TRAFFIC IMPACT STUDY

**Church at Bent Grass Meadows
El Paso County, Colorado**

PCD File No. SF268

Unresolved V1 Comments:

SHEET RD	3
-------------	---

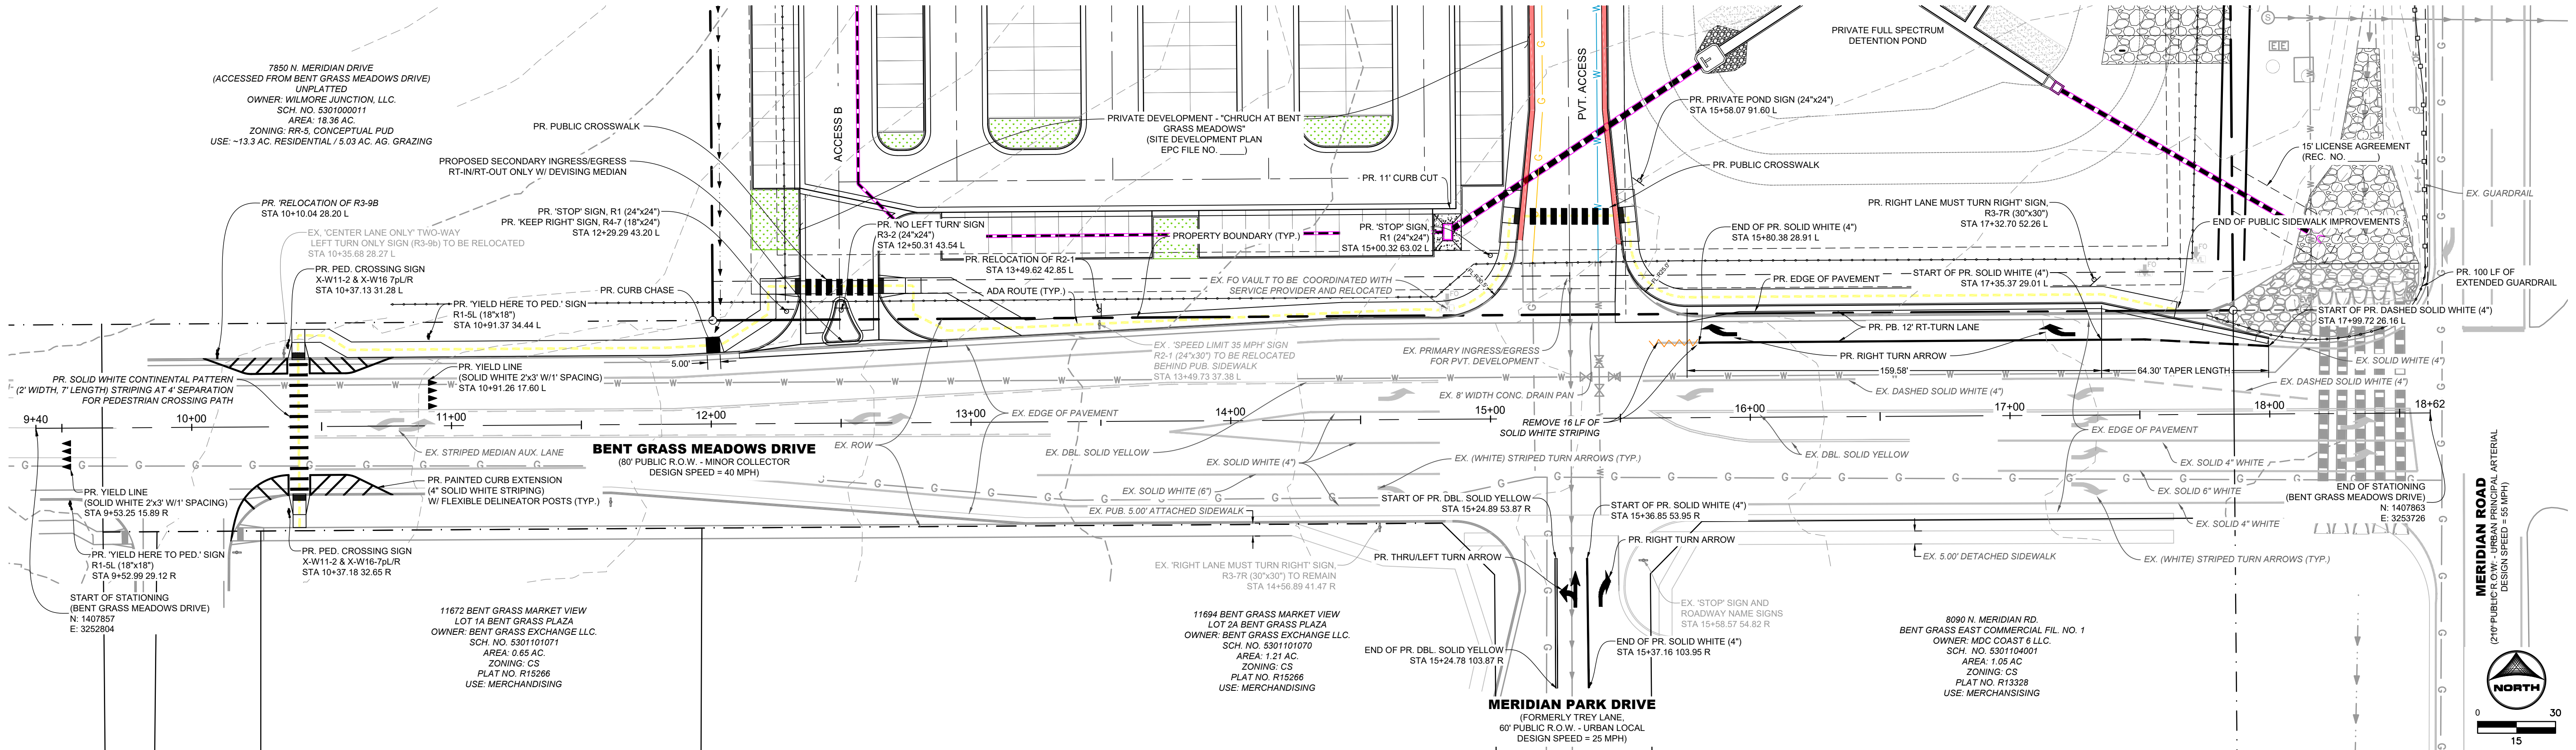
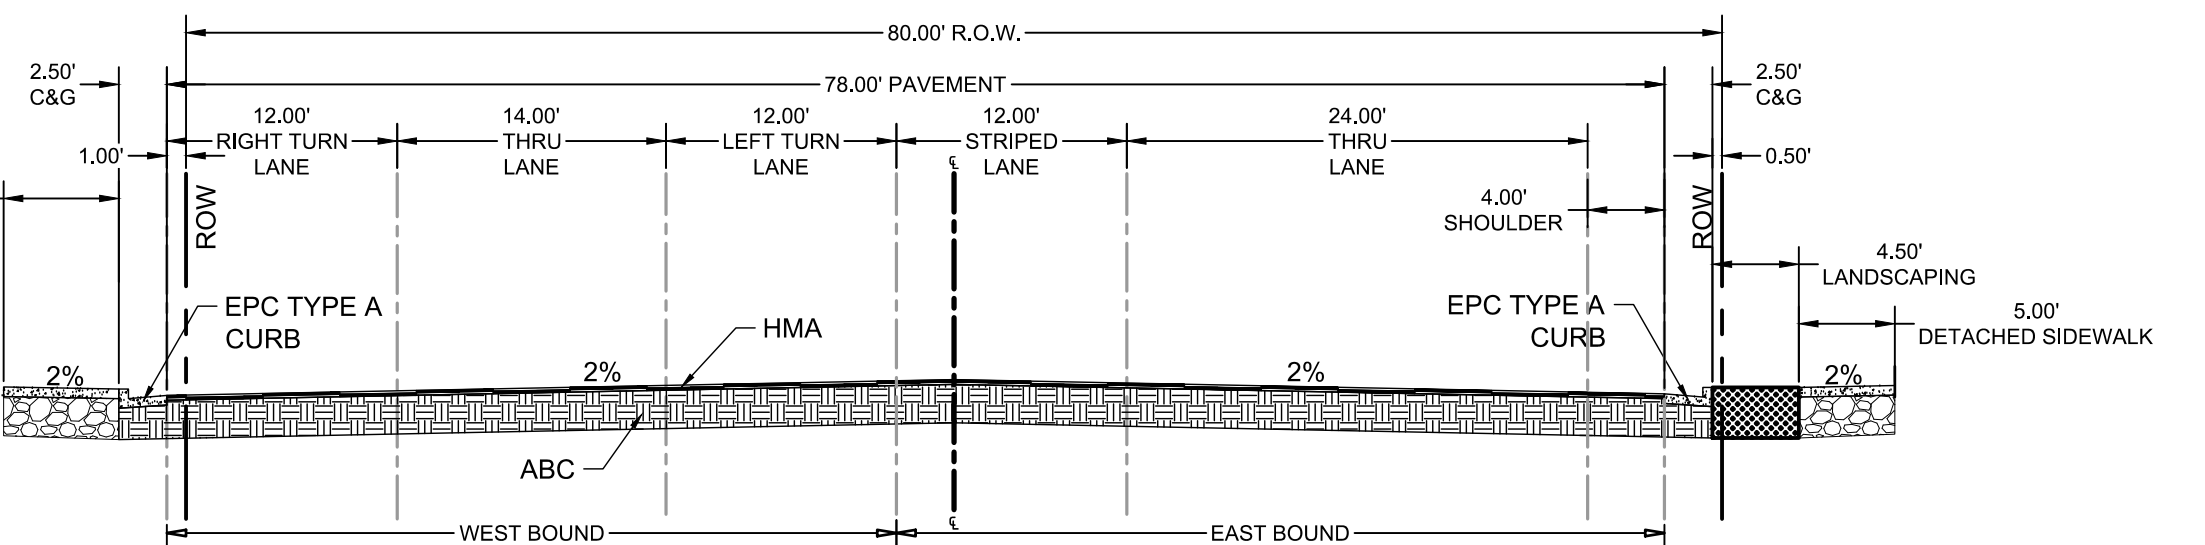
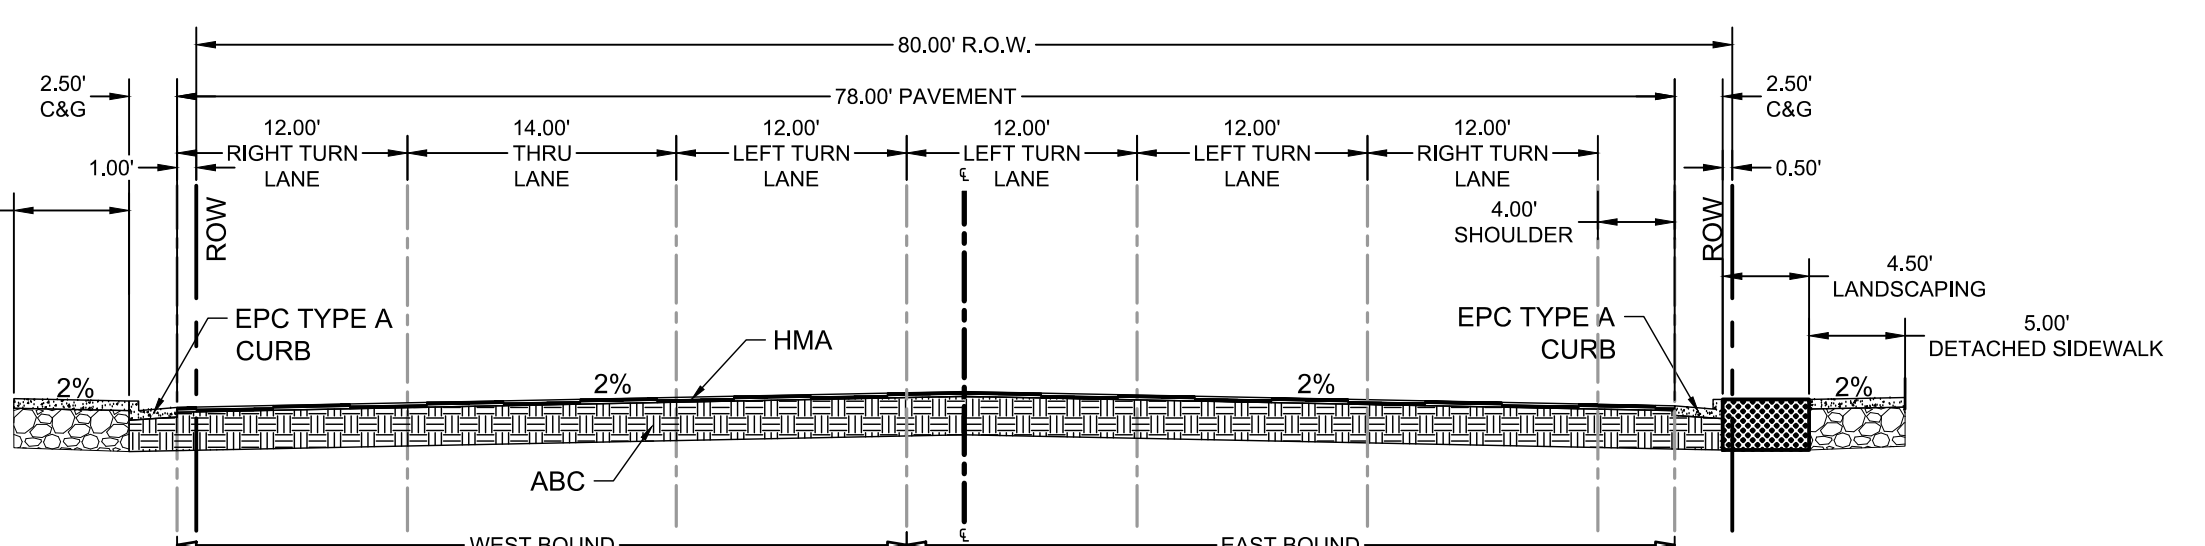
A deviation must be submitted for the W/B right turn lane into Access A and for access spacing.
